AW-344-14-HH – Further Objection – 18-3-2015

ADDITIONAL OBJECTION to AW/344/14/HH – 68 The Drive – within the Craigweil House Conservation Area and Craigweil House Area of Special Character

ROOF PLAN

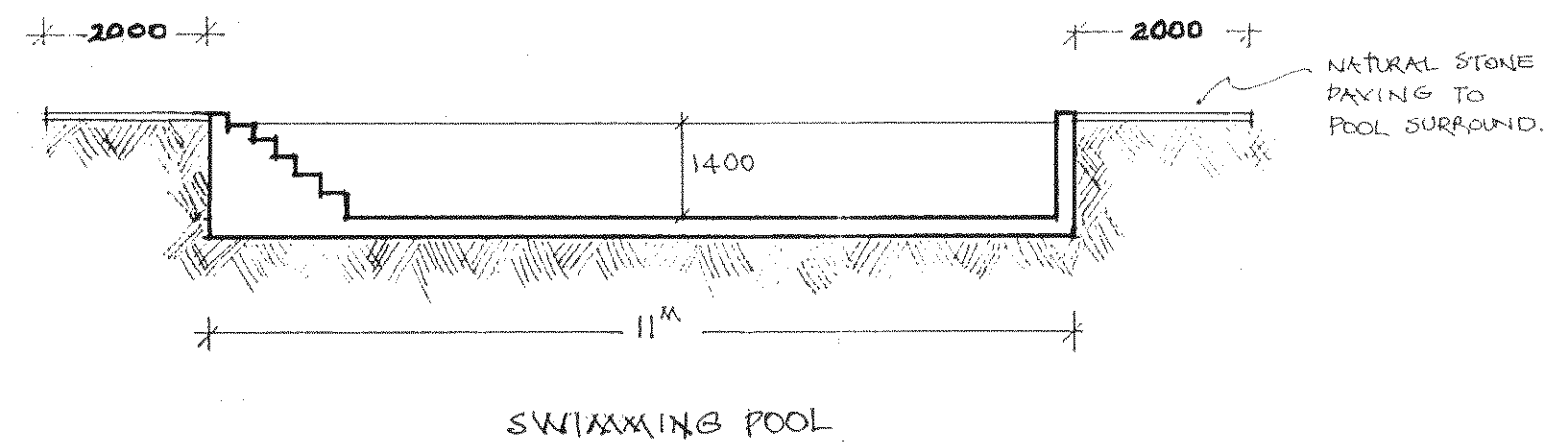
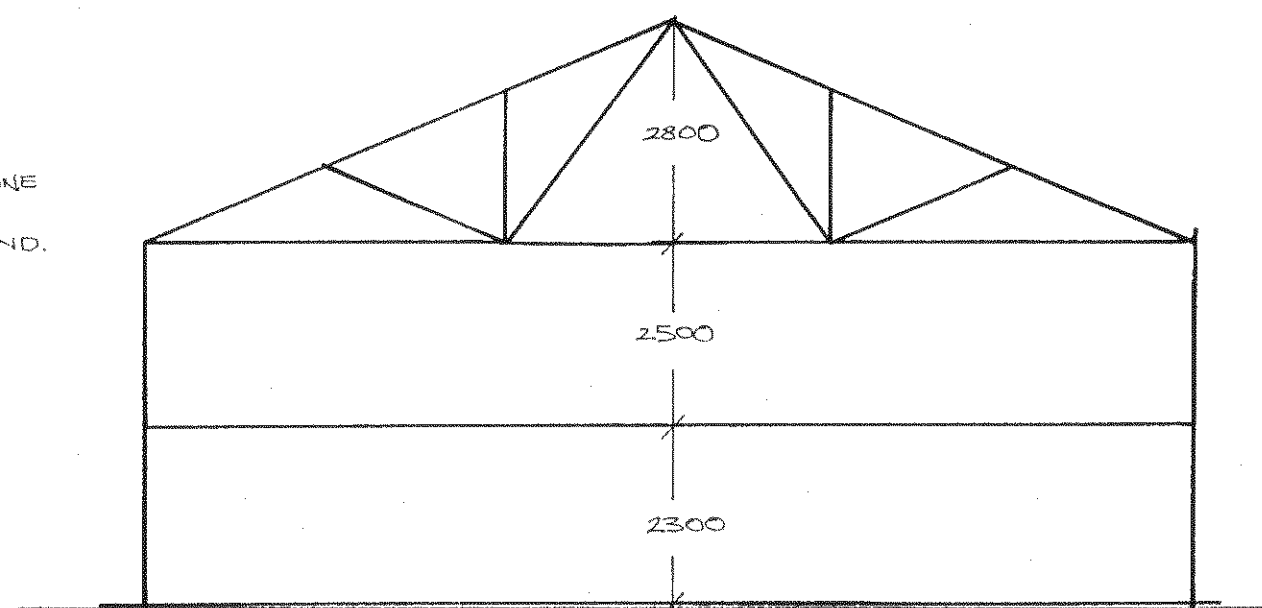
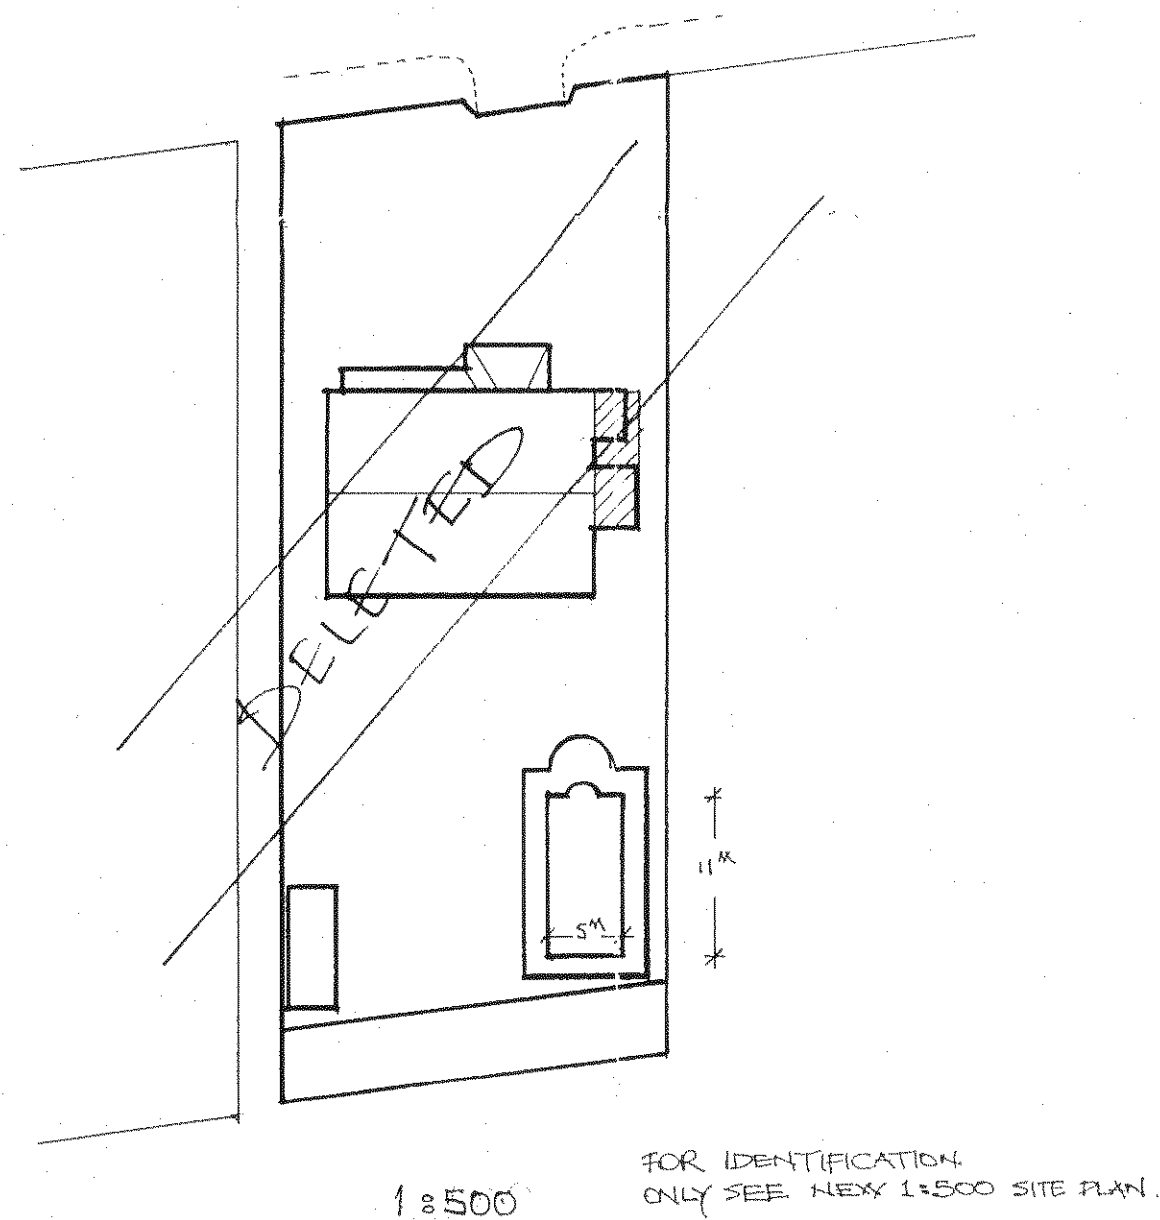
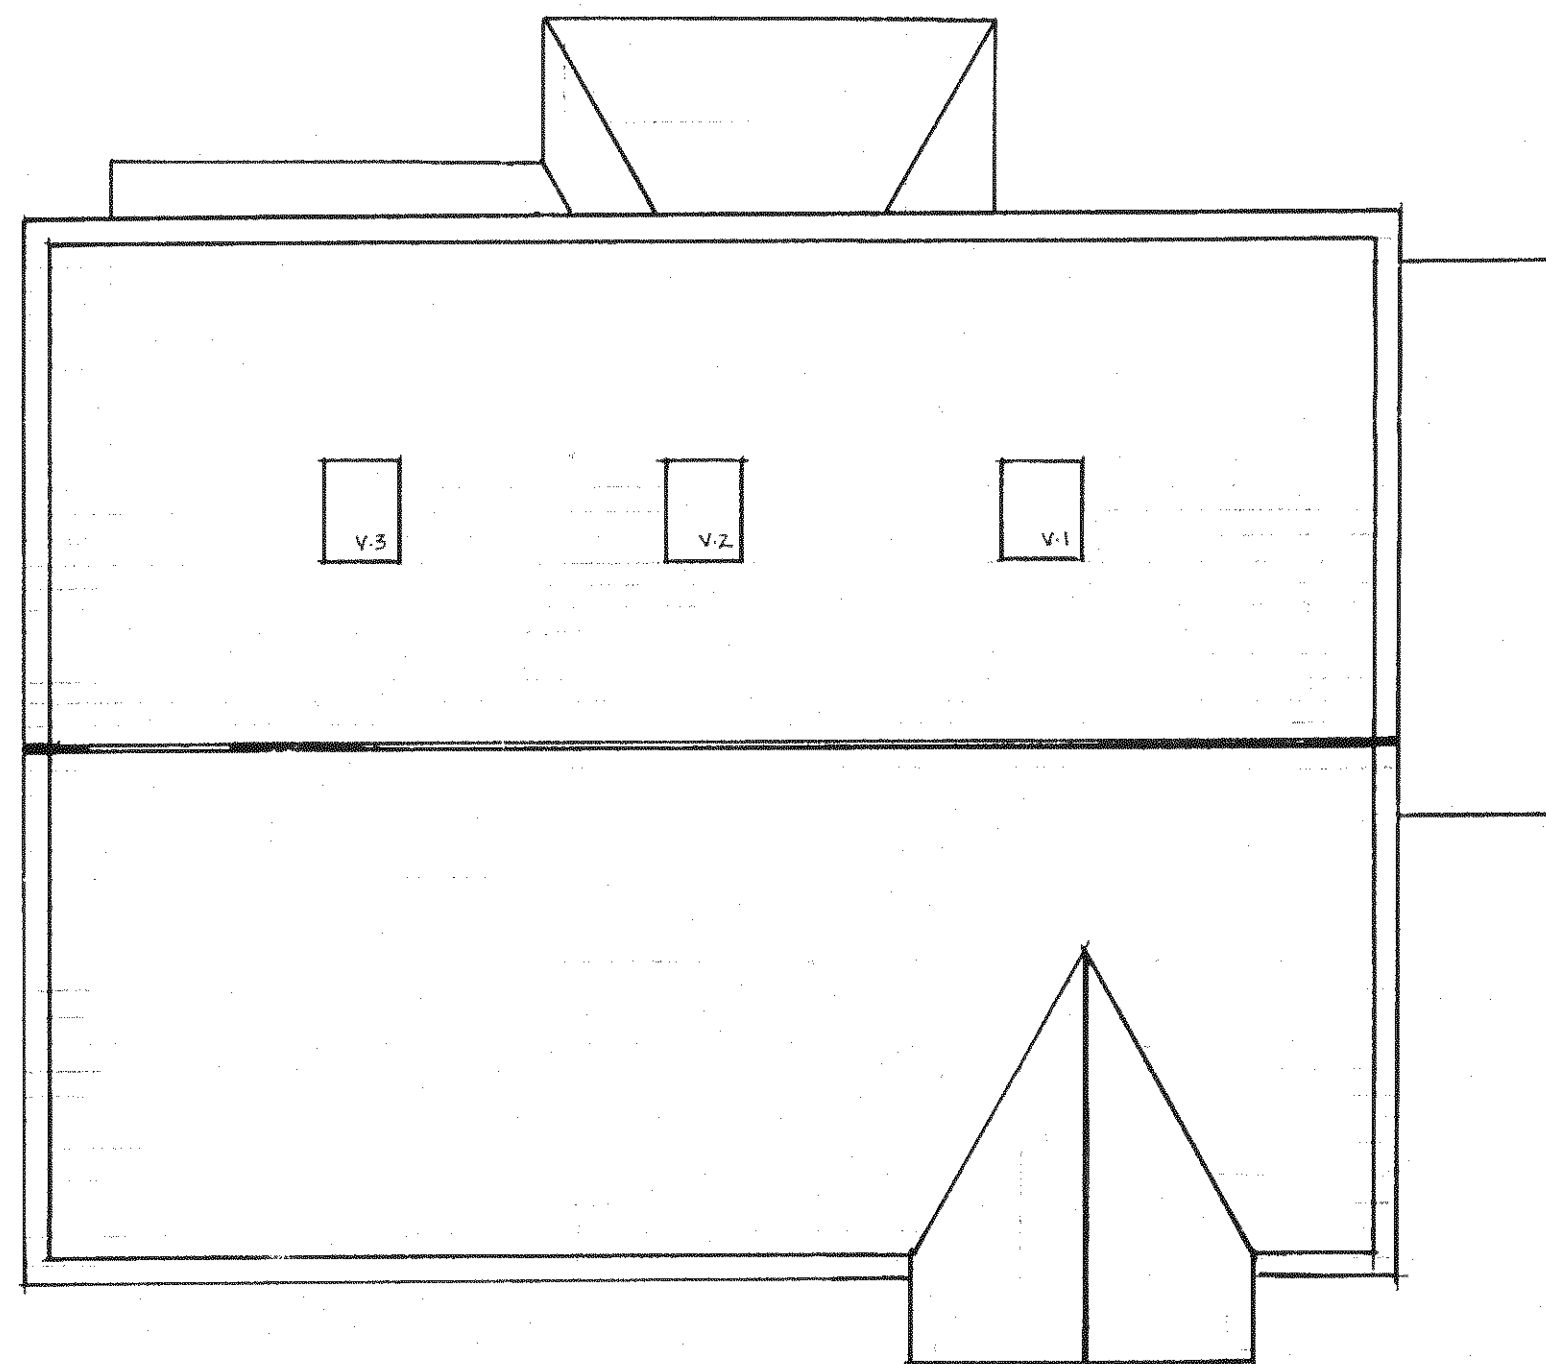
Within our objection to this planning application dated 10 February 2015, at paragraph 4 of page 4, we raised objection to the proposed removal of the existing Sussex tiling – which is relatively new and certainly not likely to be in need of replacement due to any form of structural failure – and replacement with black Welsh slate.

We consider that black Welsh slate will fail to *preserve or enhance the character or appearance or setting* of the CA and be harmful to it. We think it right, yet again, to quote the profound words of Mr. Justice Lindblom who held in the case of The Queen and Sevenoaks District Council in June 2014 that ***'Once he (the Case Officer) has found that there would be SOME HARM...to the conservation area, the officer was obliged to give that harm considerable importance and weight in the planning balance.'*** We consider that the proposed replacement of the roof tiles with Welsh slate would cause harm to the CA and ask that appropriate weight be given to this issue. We stress that similar slate at No.72 was placed pre-CA designation.
